From: Contact Centre (CRM) <contact@ribblevalley.gov.uk>
Sent: 22 February 2024 14:42
To: Planning
Subject: Planning Application Comments - 3/2023/0866 FS-Case-589158453

Planning Application Reference No.: 3/2023/0866

Address of Development: land adjacent to no 9 Old Road Chatburn BB7 4AB

Drawing Title
Proposed Boundary Fence
And Wall Details

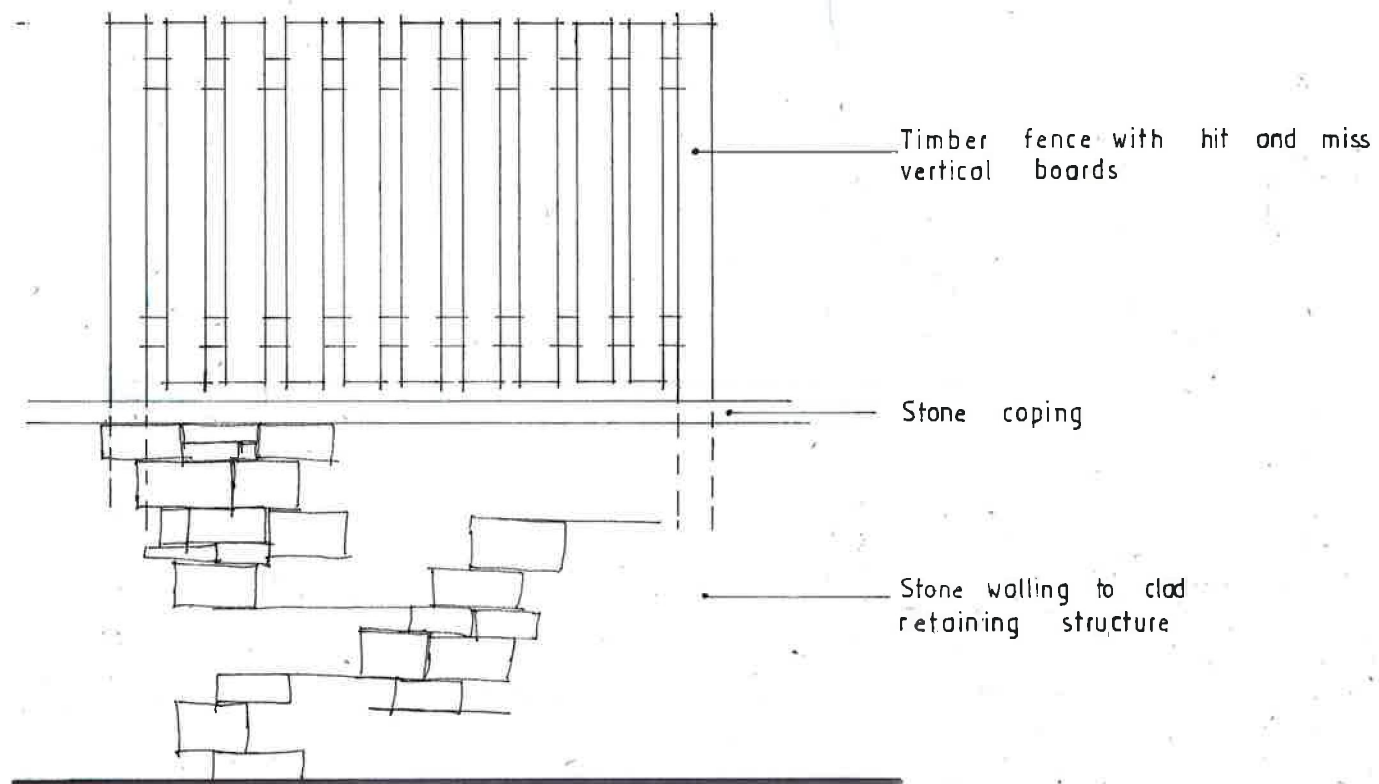
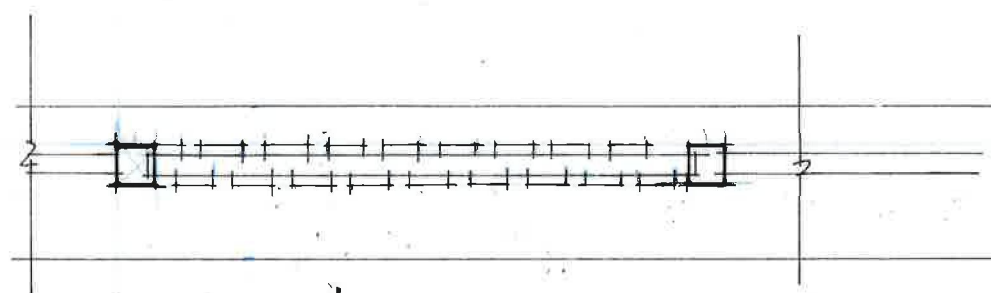
The back gardens of houses on Old Road experience high winds funnelled up the hill. In recent winds [REDACTED] The 1.8m high timber fence on top of a high retaining wall as specified in the drawings would be unlikely to last. Any fencing would be put under immense strain and would surely also impose loading on the retaining wall – again threatening the safety of those properties on HHC.

Drawing file: planx_downloads / 23_0866_Landscape_Strategy_RevC_7feb24.pdf

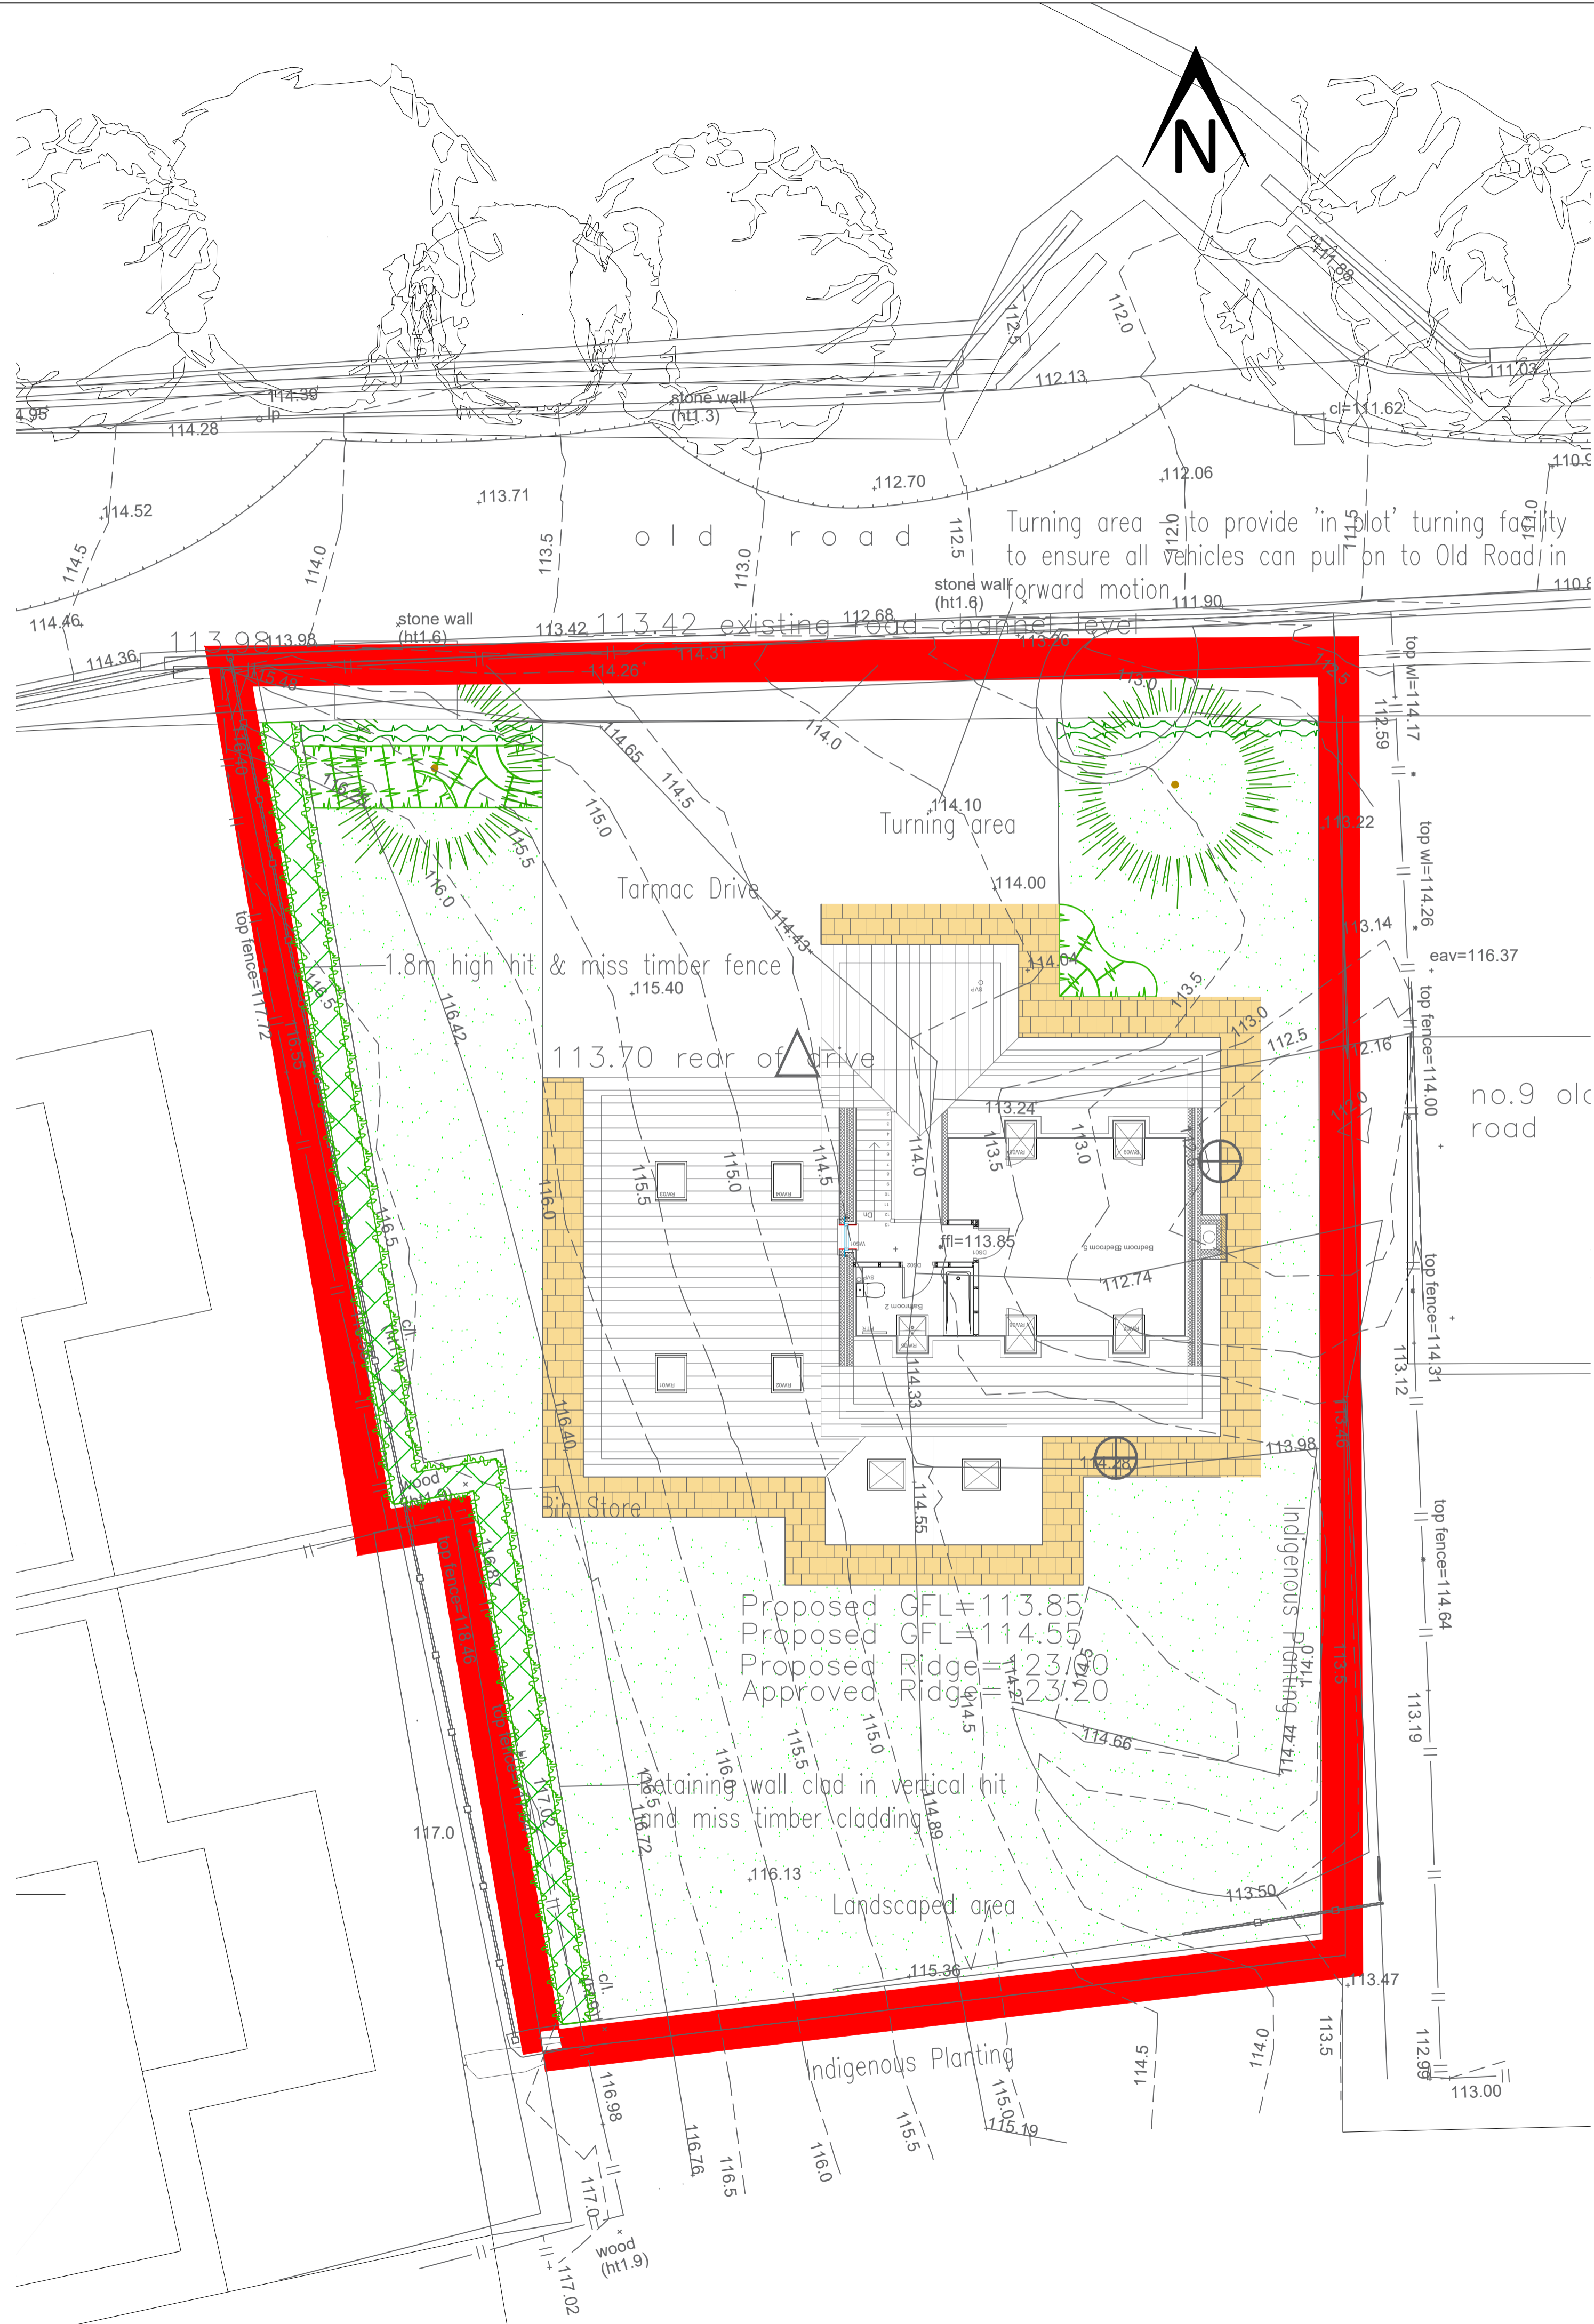
The key on the drawing does not show any pathway, but I assume the area shaded in yellow is a pathway around the house. The house design includes open access through very wide bi-fold patio doors onto the rear garden. However, in reality I would expect any houseowner would want to benefit from a larger patio area rather than a narrow path. This would further extend the hard standing area

The drawing does not show any protection of the remaining area of unimproved calcareous grassland shown on previous ecological surveys. This is in the SE corner of the site. This is significant, as according to the conditions, all access for construction should be from the rear of the property over the protected area. The drawings need to clearly indicate the protected area and the maintenance plan needs to include protection specifications.

Drawing file: planx_downloads / 23_0866_Top_Survey_29jan24.pdf

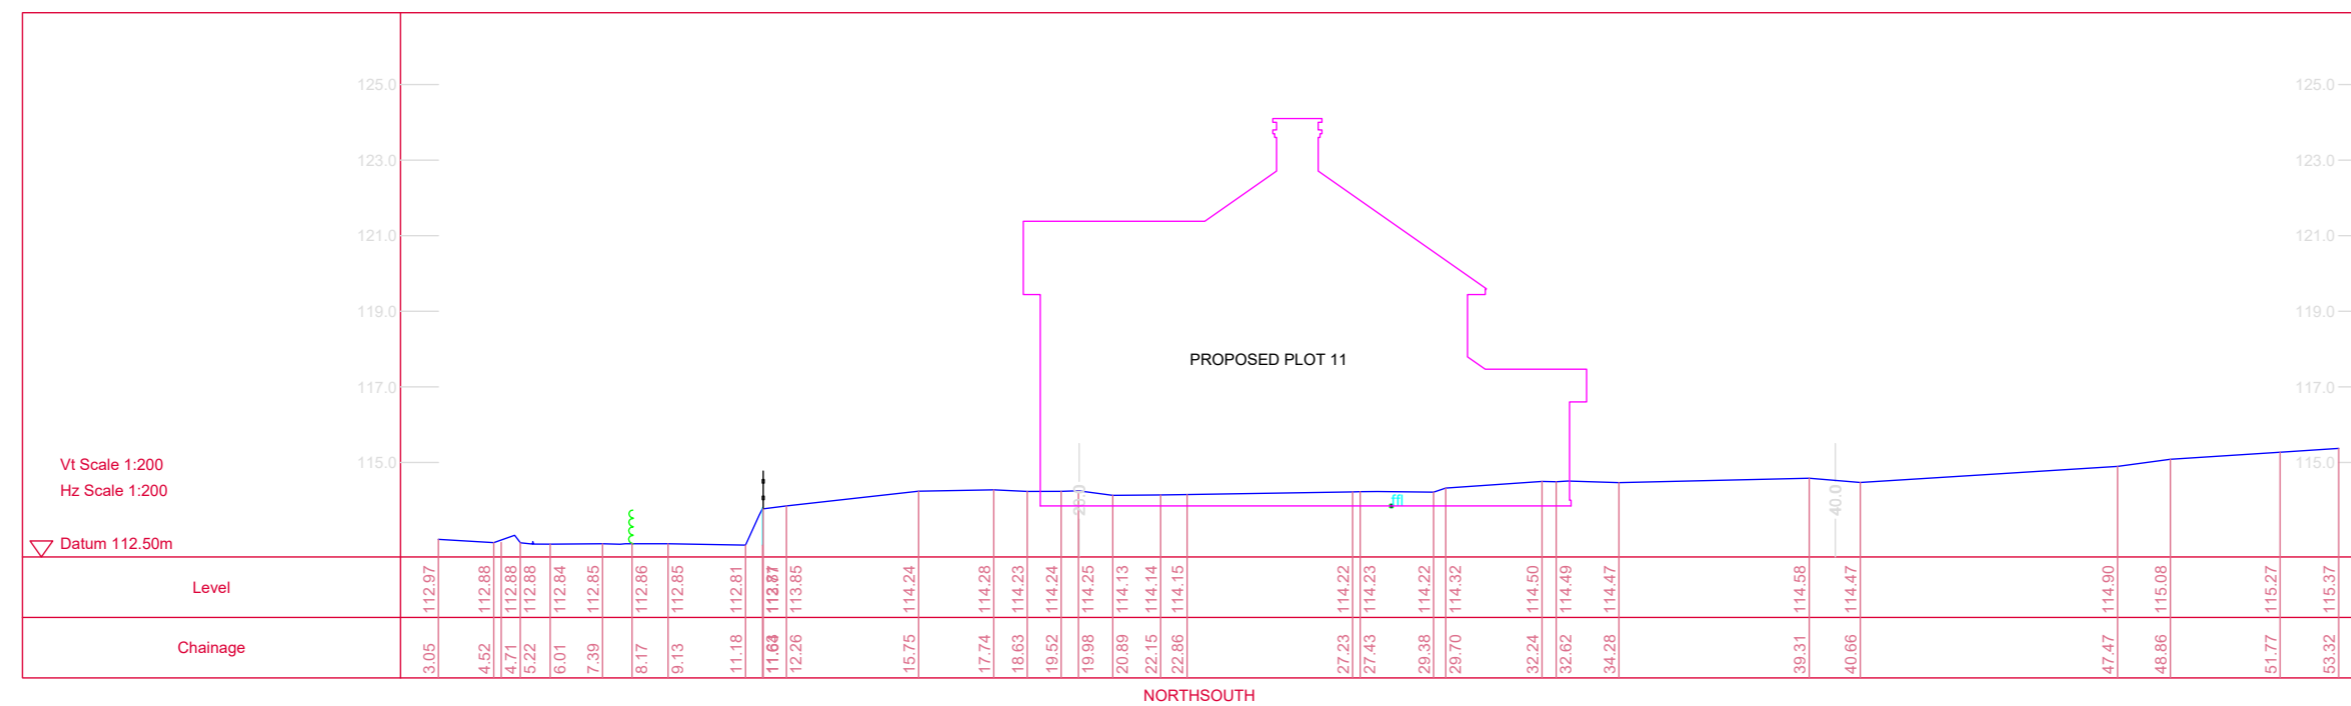
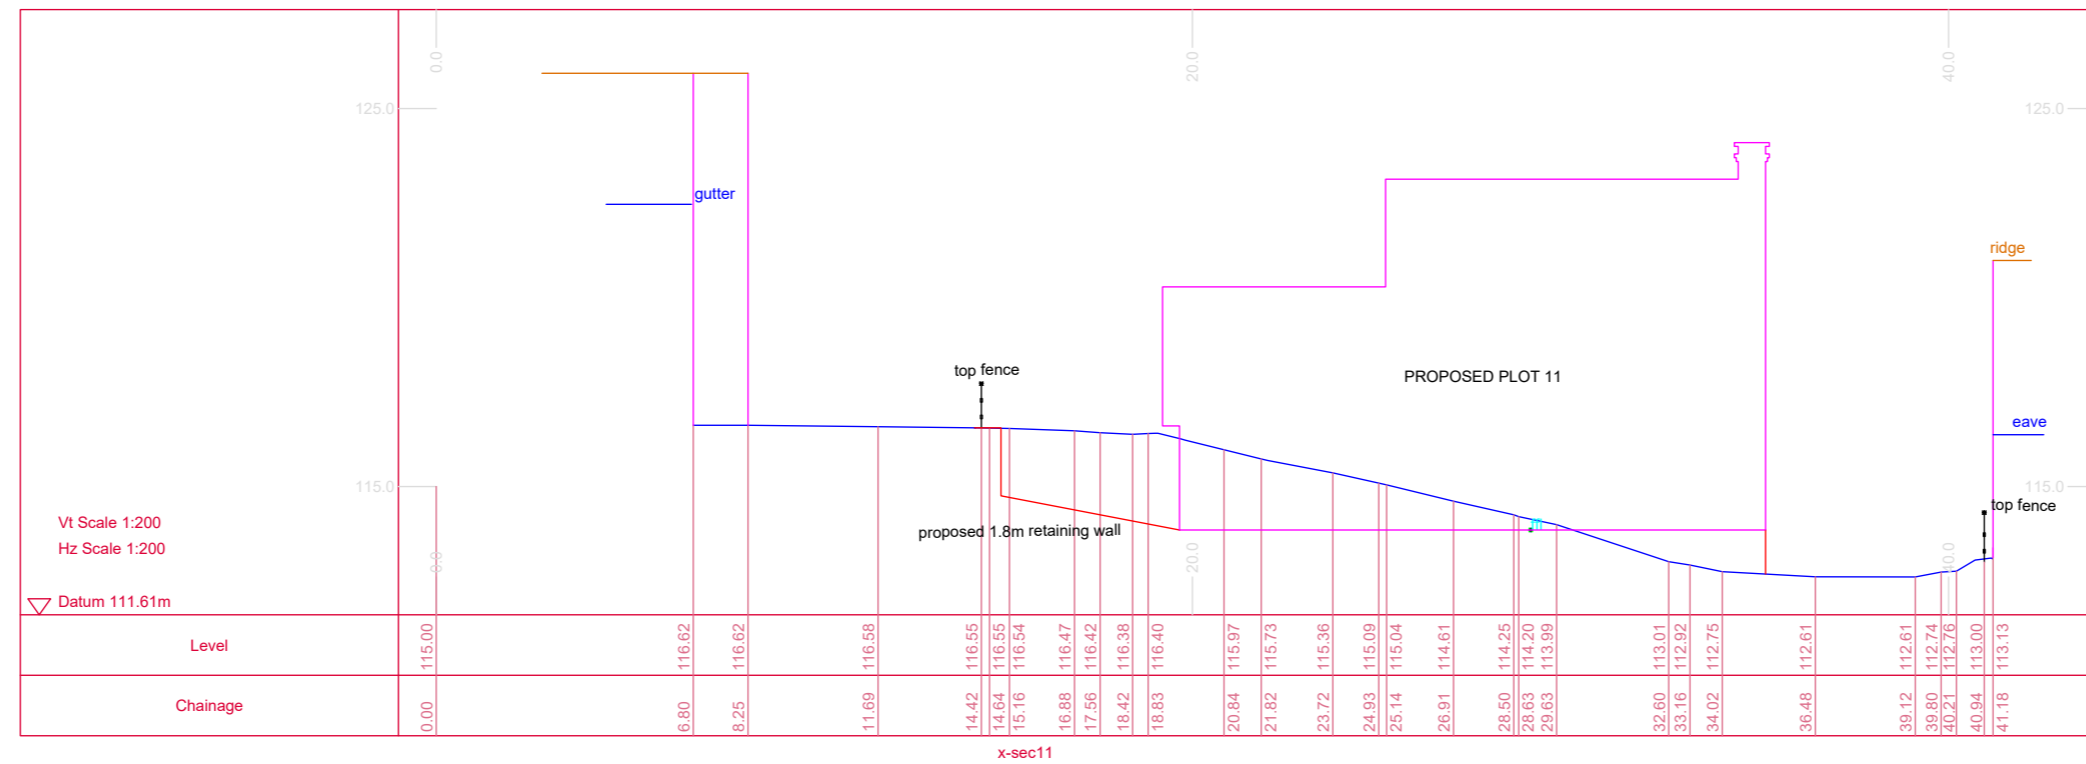
I would like to see details of the completed due diligence with regard to the specifications of the retaining wall in order to guarantee protection of the properties of nos 1 2 and 3 HHC. I believe a full engineer's report needs to be submitted to show what needs to be done in order to provide a safe solution and a guarantee that the wall will not fail. Have Health and Safety been advised of the proposals? If the retaining wall fails what recourse do the properties on HHC have?
